Response to Planning application from Hertfordshire County Council (T and CP GDP Order 2015)

District ref: 6/2020/3306/FULL
HCC ref: WH/4810/2020
HCC received: 16 December 2020
Area manager: Matthew Armstrong
Case officer: Paul Marshall

52 & 54 BRIDGE ROAD WELWYN GARDEN CITY AL8 6UR

Construction of two, two-storey detached houses with accommodation in the roof space and associated parking and access on the land to the rear of 52 & 54 Bridge Road.

Drawing No: 1644.P.02

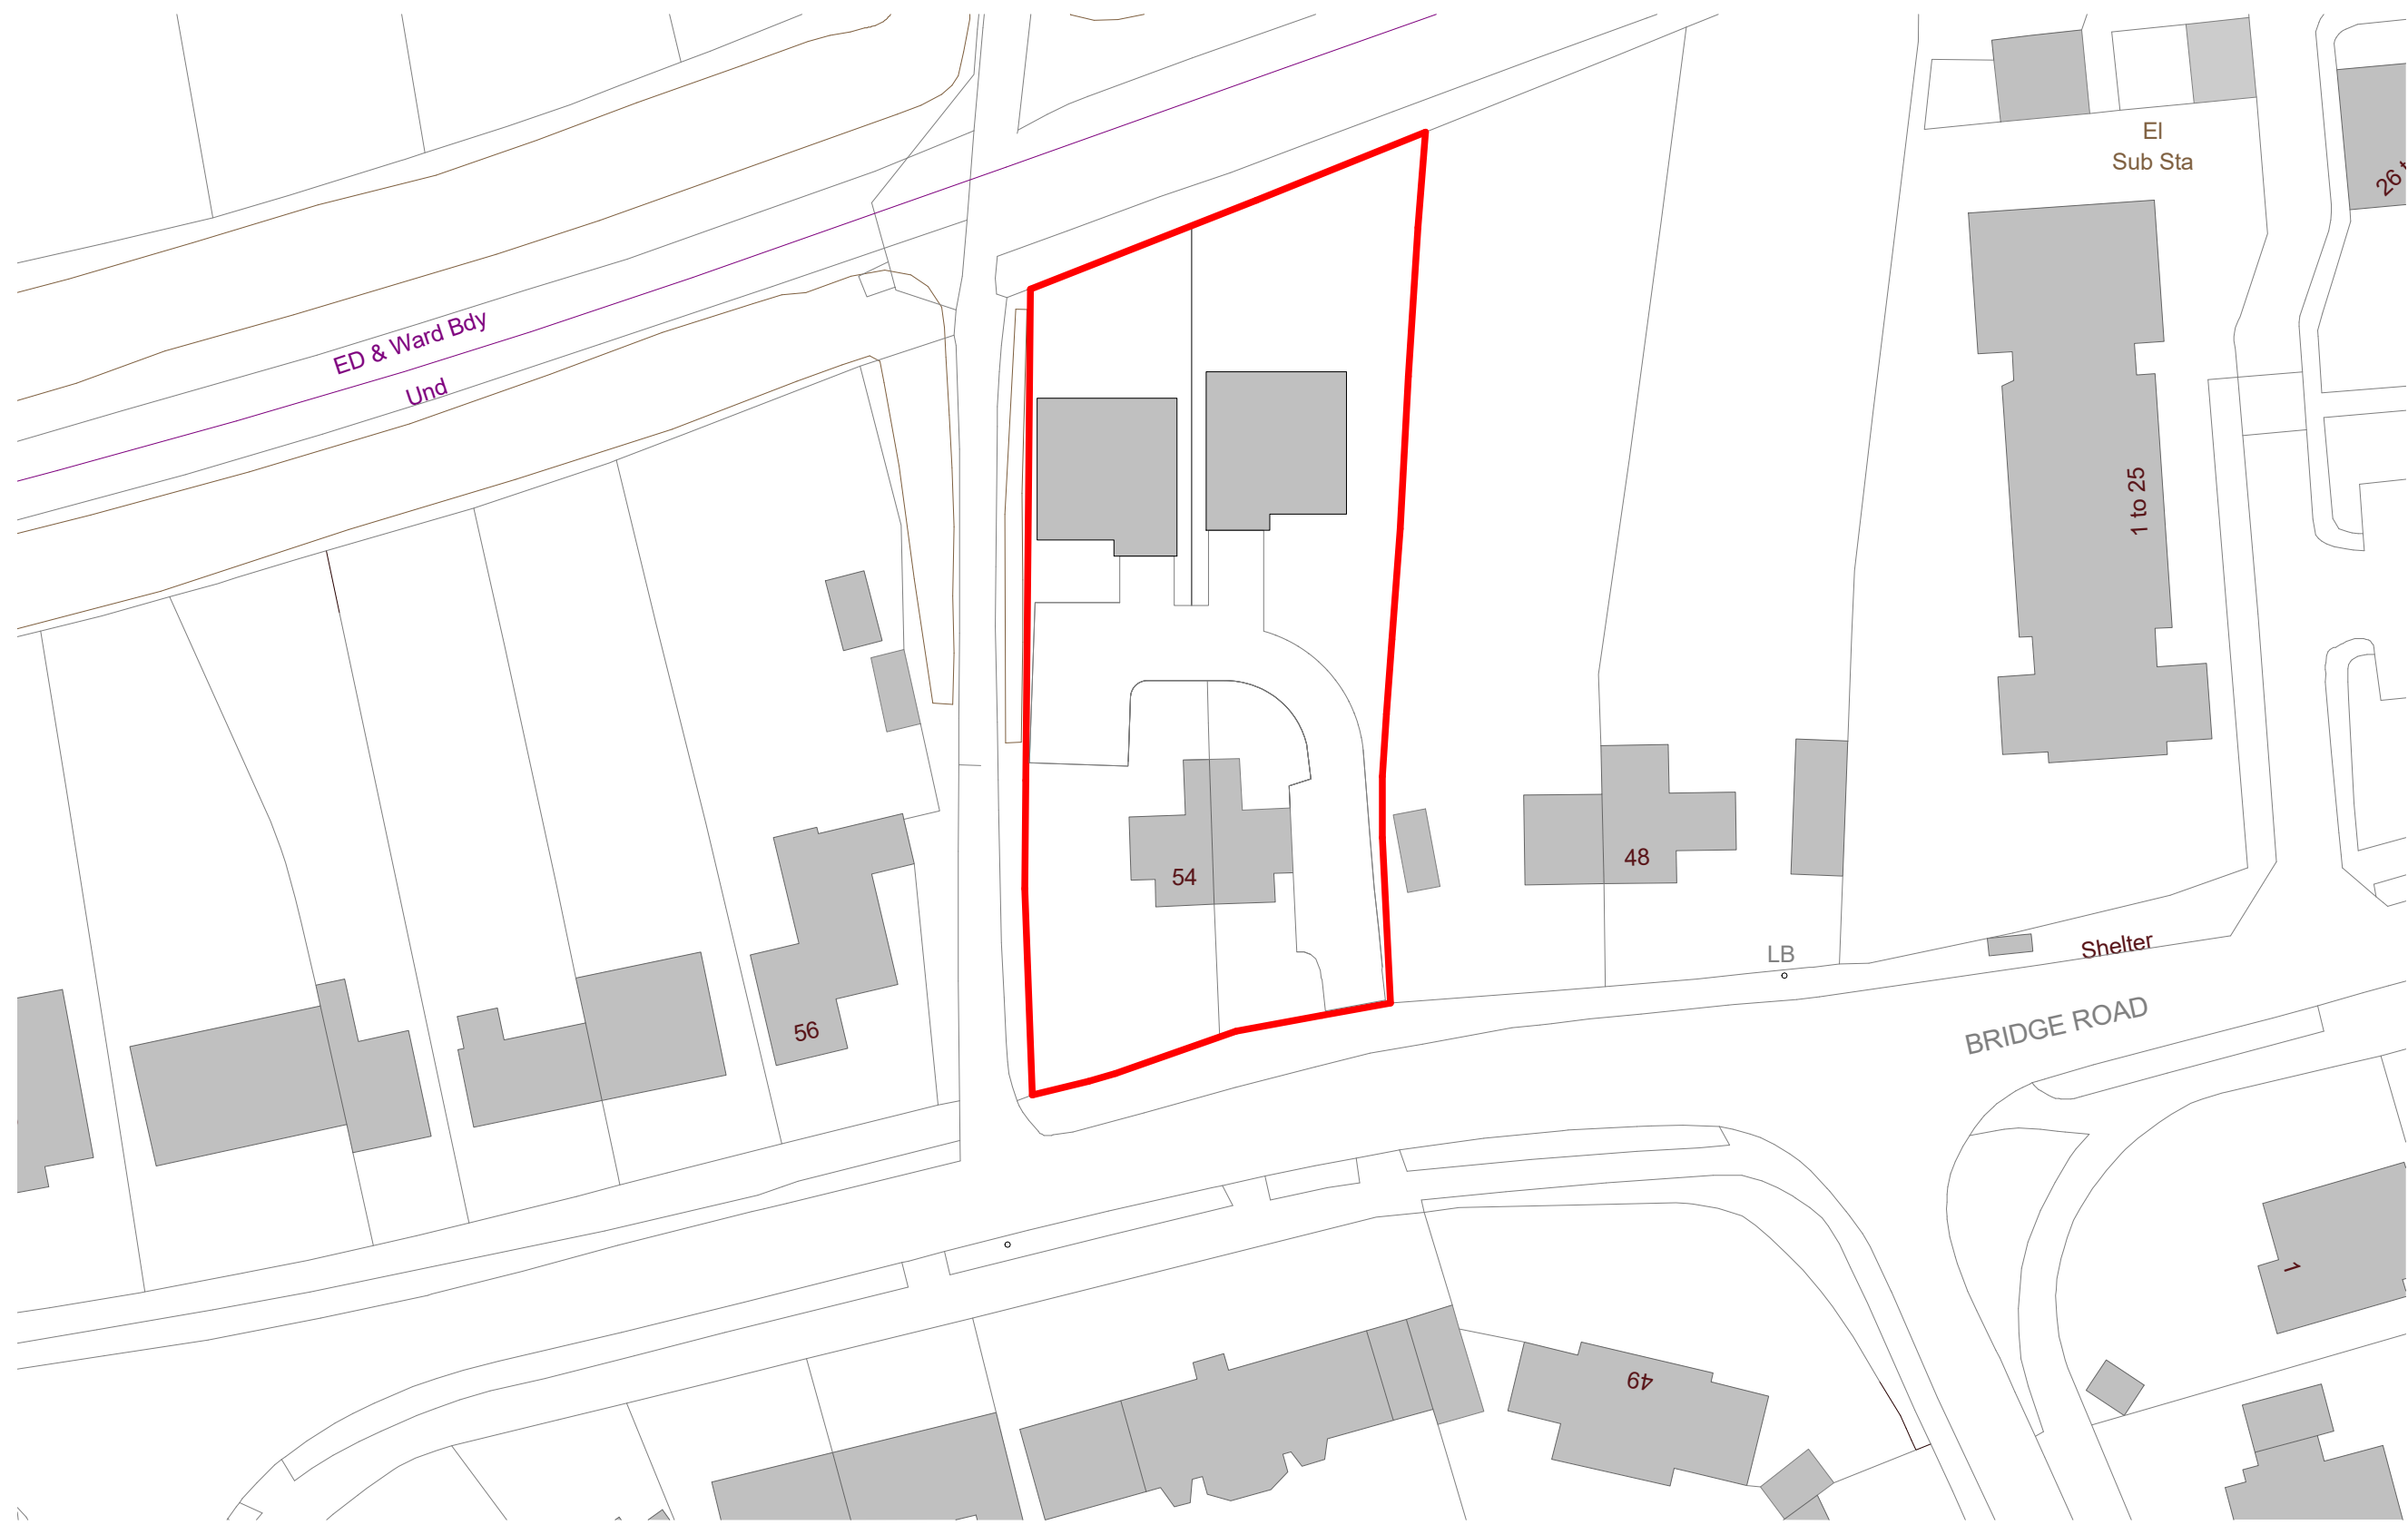
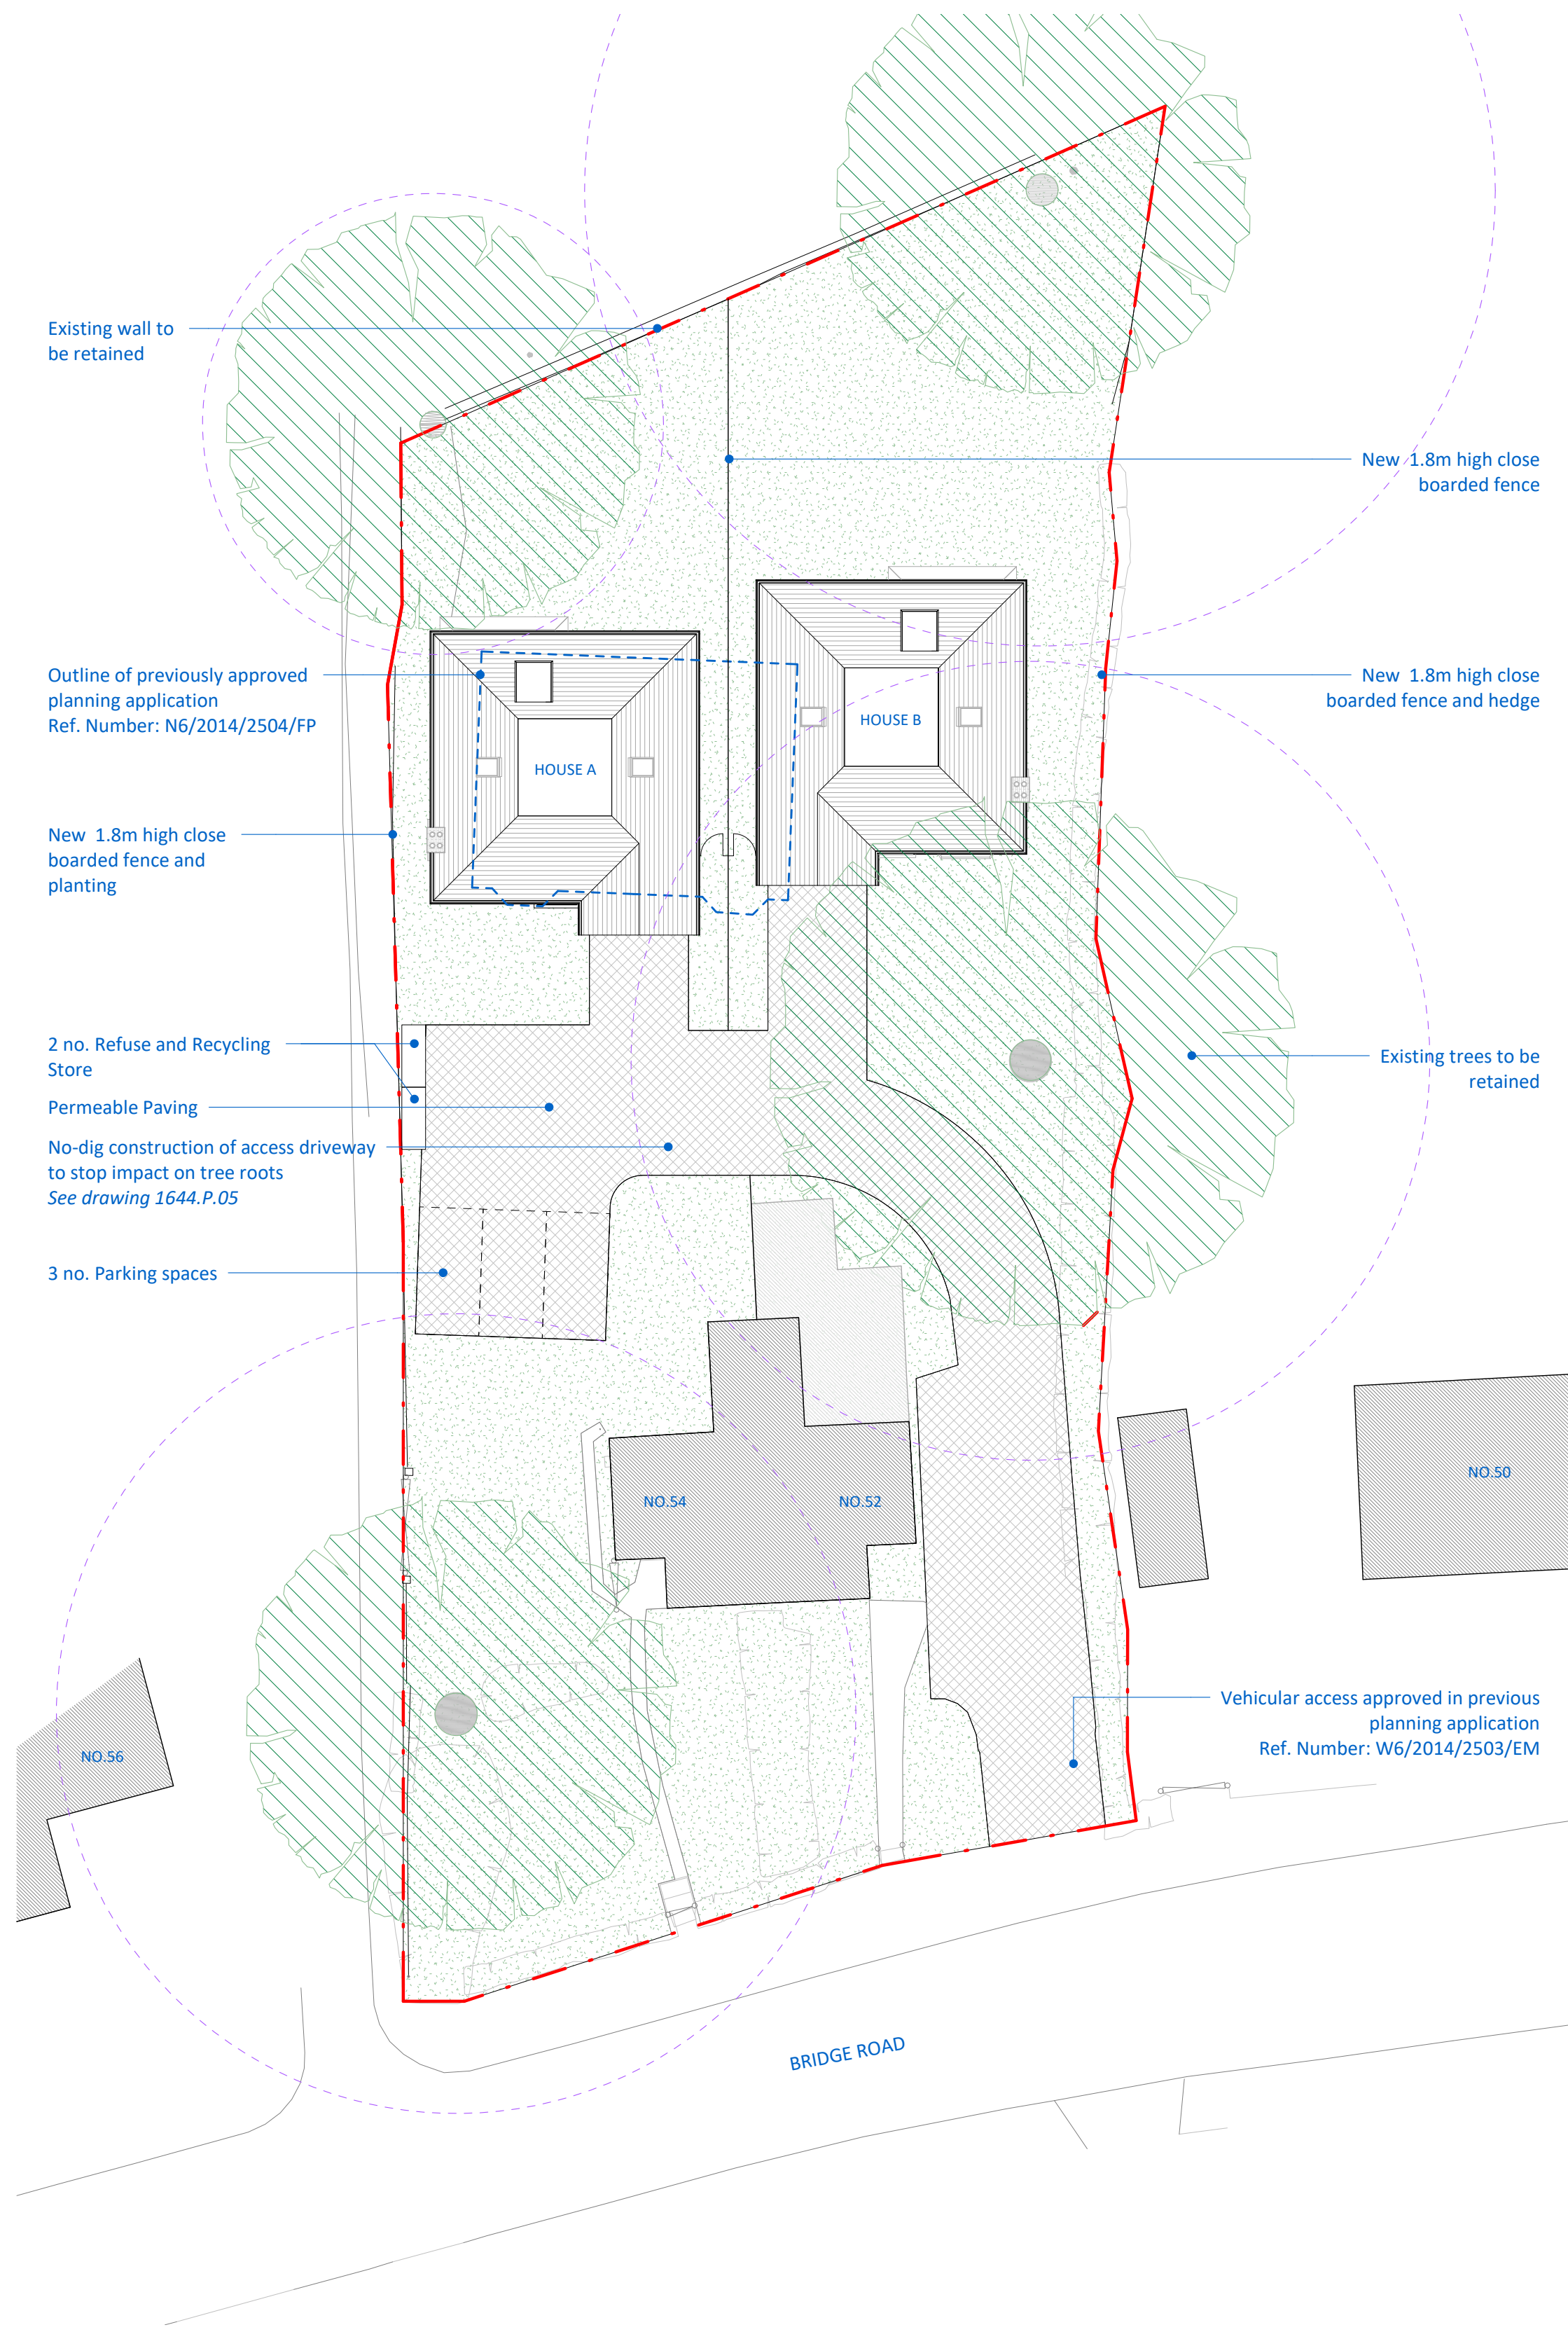
The proposals do not meet the minimum required cycle parking facilities.
Parking bays do not achieve the new 5m x 2.5m parking standards laid out by HCC.

Vehicles can enter the site and exit in a forward gear. Car parking spaces at the site are in accordance with guidance as set out in MfS and Roads in Hertfordshire. Car parking spaces are measured at 2.4 x 4.8 do not achieve the new 5m x 2.5m parking standards laid out by HCC. Welwyn Hatfield Borough Council (WHBC) is the parking authority and therefore would ultimately need to be satisfied with the level of proposed car parking.

The provision of any gates should be set back a minimum of 6.0m from the edge of the highway carriageway. Any existing gates would be needed to be altered to meet this requirement or removed.

Project: RO Bridge Road, 52&54 AL8 6UR
Client: Mr. M. Tabrizi
Title: Proposed Plans and Elevations (House A)
Scale @ A1: 1 : 100
Drawing No: 1644.P.03

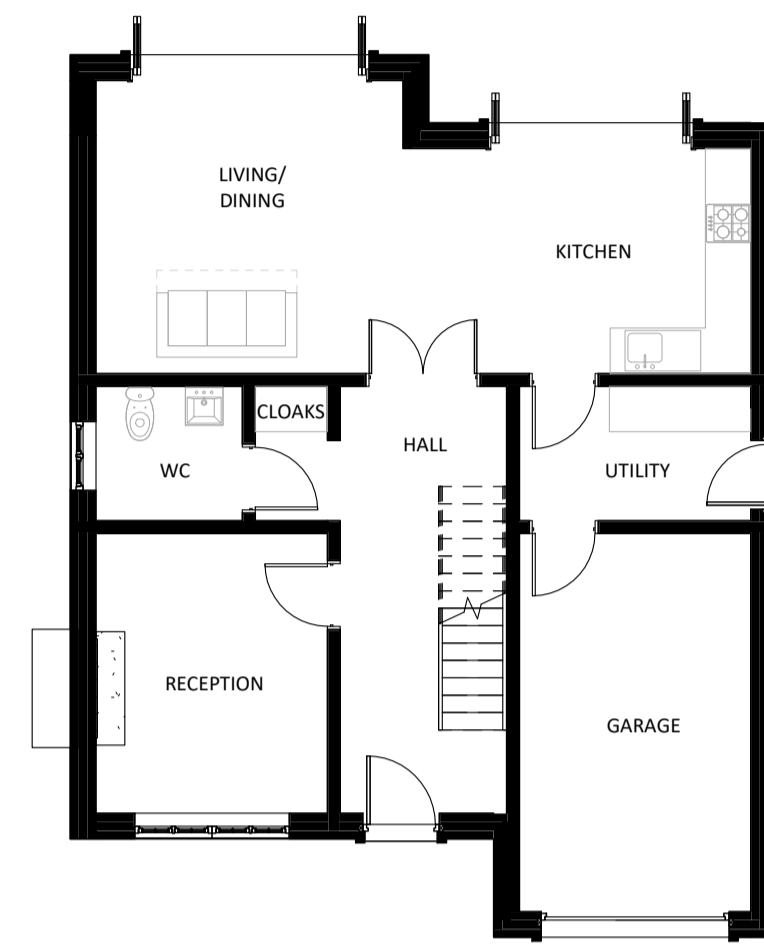
The integral garages are approx. 3 x 5.5m. Manual for Streets 8.3 recommends 3 x 6m. With this in mind, the latest govt guidance: 'Cycle Infrastructure Design' DfT Local Transport Note 1/20 (July 2020) recommends for cycle parking storage should be 1.8m in length by 0.3m space between cycles. There should be parking for 2 cycles per dwelling. With no proposed outside covered cycle parking and a smaller than average garage the proposals do not meet the minimum required cycle parking facilities.
